Final Acceptance Punchlist
El Paso County – Department of Public Works - Stormwater Section

Project Name:	Hannah Ridge F7
EDARP Filing Number(s):	CON1932, SF1840
ESQCP Number:	ESQ1926
Attendees:	DPW SW: Dylan Finley DPW Development Services: Brad Walters, Spencer Pirzadeh Developer: Adam Doyle
Date of Walk-Thru:	10/12/2023
Walk-Thru Number:	1

**DETENTION FACILITY NO. 1
POND OUTLET PROFILE**
SCALE: HORIZONTAL 1"=30'
VERTICAL 1"=3'

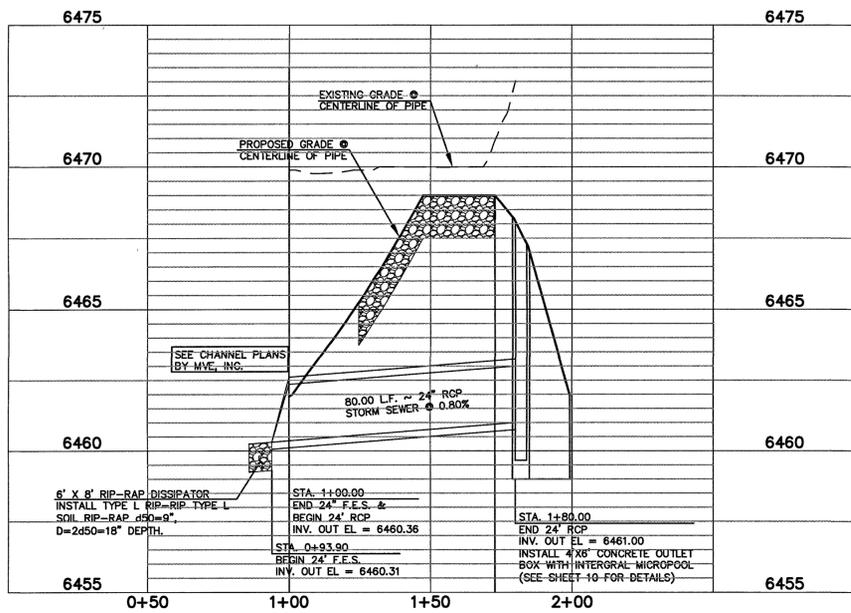
- Engineering Record Drawings (as-builts) consistent with Section 5.10.6 of the ECM.
 - Even if everything was built exactly per plan, we need an electronic PDF of the original drawings to be signed, dated, and stamped with "As-Built" on each sheet.
 - Differences from design to as-built conditions to be shown in red text with red clouds/bubbles.
 - Site specific items to address:
 - Be sure to check invert of downstream end of outlet pipe. It is lower than the low flow channel in the downstream channel. Because of this, the riprap apron at the outlet of pipe will hold water

and not drain properly to the low flow channel. It is unclear from this filing's set of plans alone if this was the desired elevation of the invert.

<p>HANNAH RIDGE AT FEATHERGRASS FIL. 7 CONSTRUCTION DRAWINGS</p> <p>DETENTION FACILITY NO. 1</p> <p>OUTLET BOX DETAILS</p> <p>7/15/19</p>			
DESIGNED BY	MAW	SCALE	DATE
DRAWN BY	MAW	(H) 1" = N/A	SHEET 13 OF 14
CHECKED BY	(V) 1" = N/A	JOB NO.	1116.07

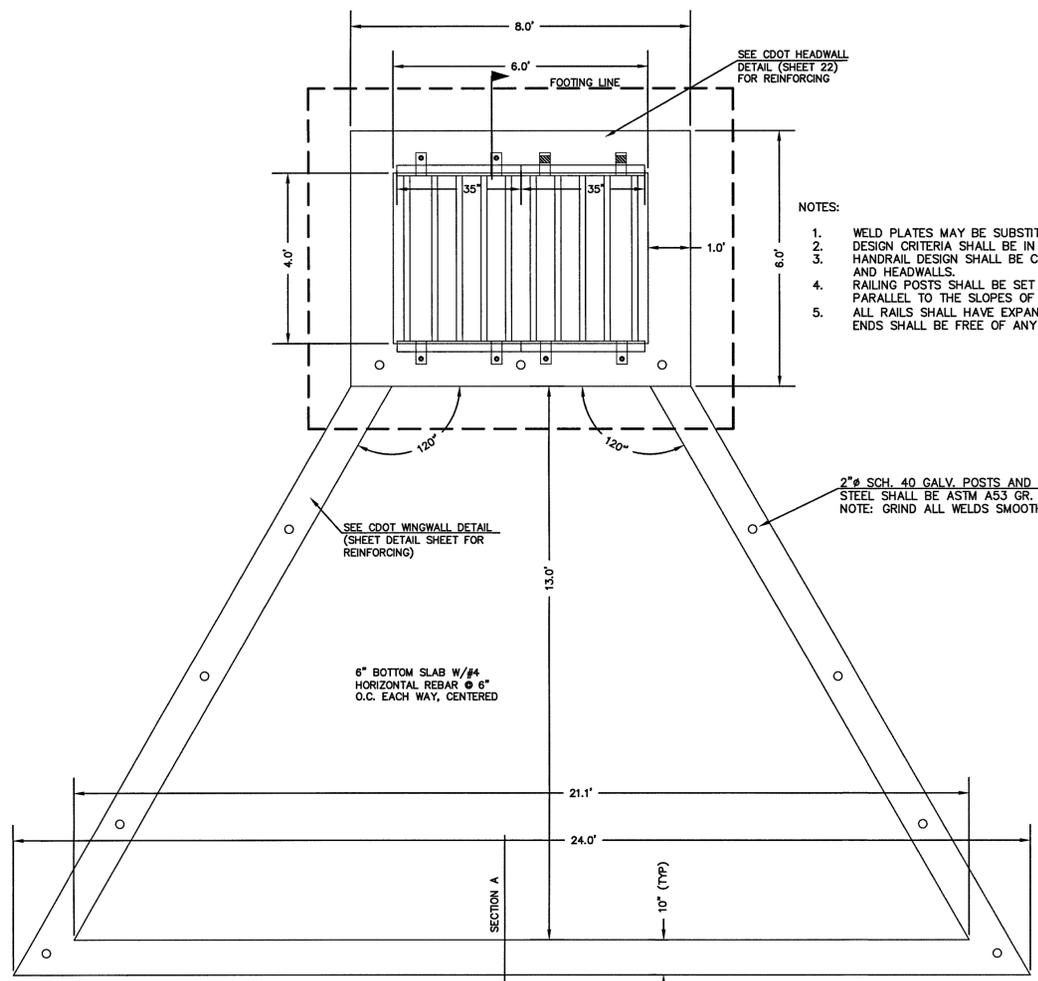
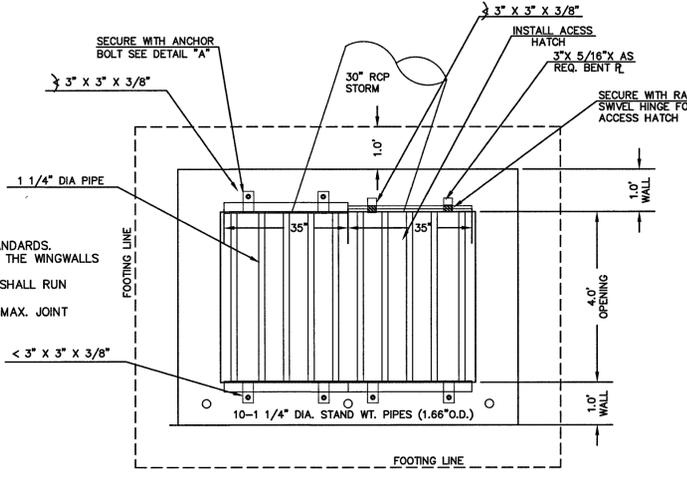
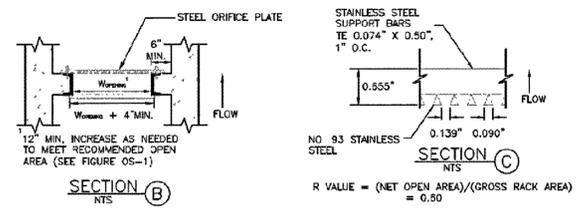
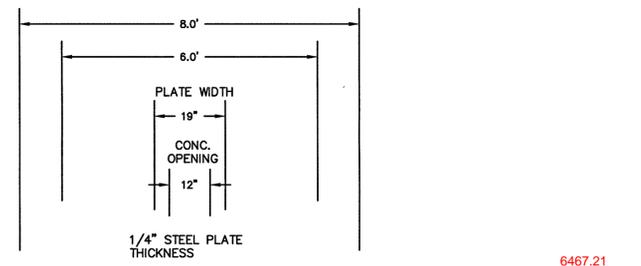
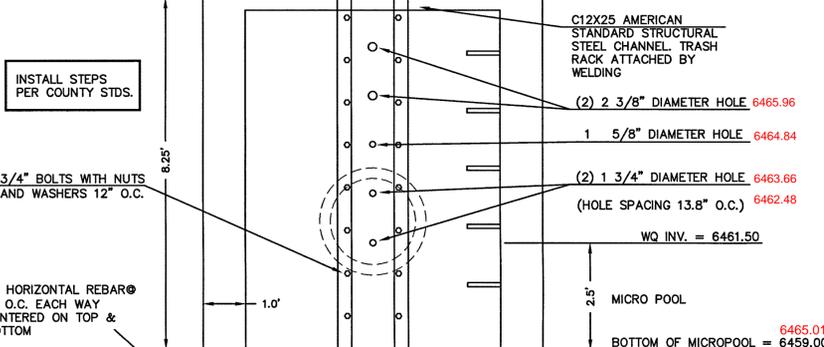
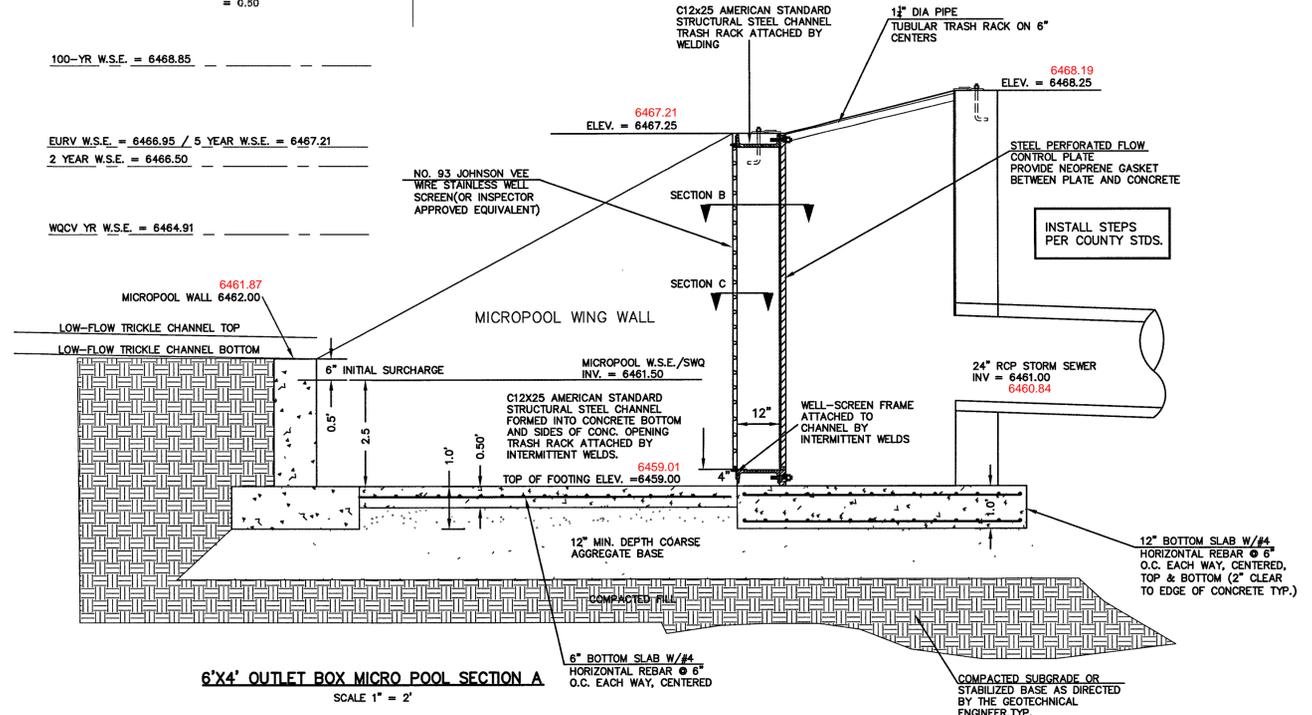
- Detail at the top of Sheet 13 of 14 shows the outlet pipe as 30". This should be revise to 24" in the as-builts.
- Volume Certification Letter(s) for pond(s), see ECM Chap 5.10.6.B for details on what type of statement should be included in the letter.

- Site specific items to address:
 - The orifice plate was installed such that there is a vertical orifice at the top of it that is not accounted for in the UD-Detention spreadsheet. Update calcs or field condition.

- The orifice hole spacing shown on Sheet 13 of 14 does not match spacing shown in UD-Detention spreadsheet (14.4" O.C.) on PDF page 90 of 96 of FDR. Address discrepancy in as-builts (drawings and/or updated UD-Detention)

- The micro screen shown on Sheet 13 of 14 Does not match type shown in UD-BMP spreadsheet on PDF page 82 of 96 of FDR. Address discrepancy in as-builts (drawings and/or updated UD-BMP)
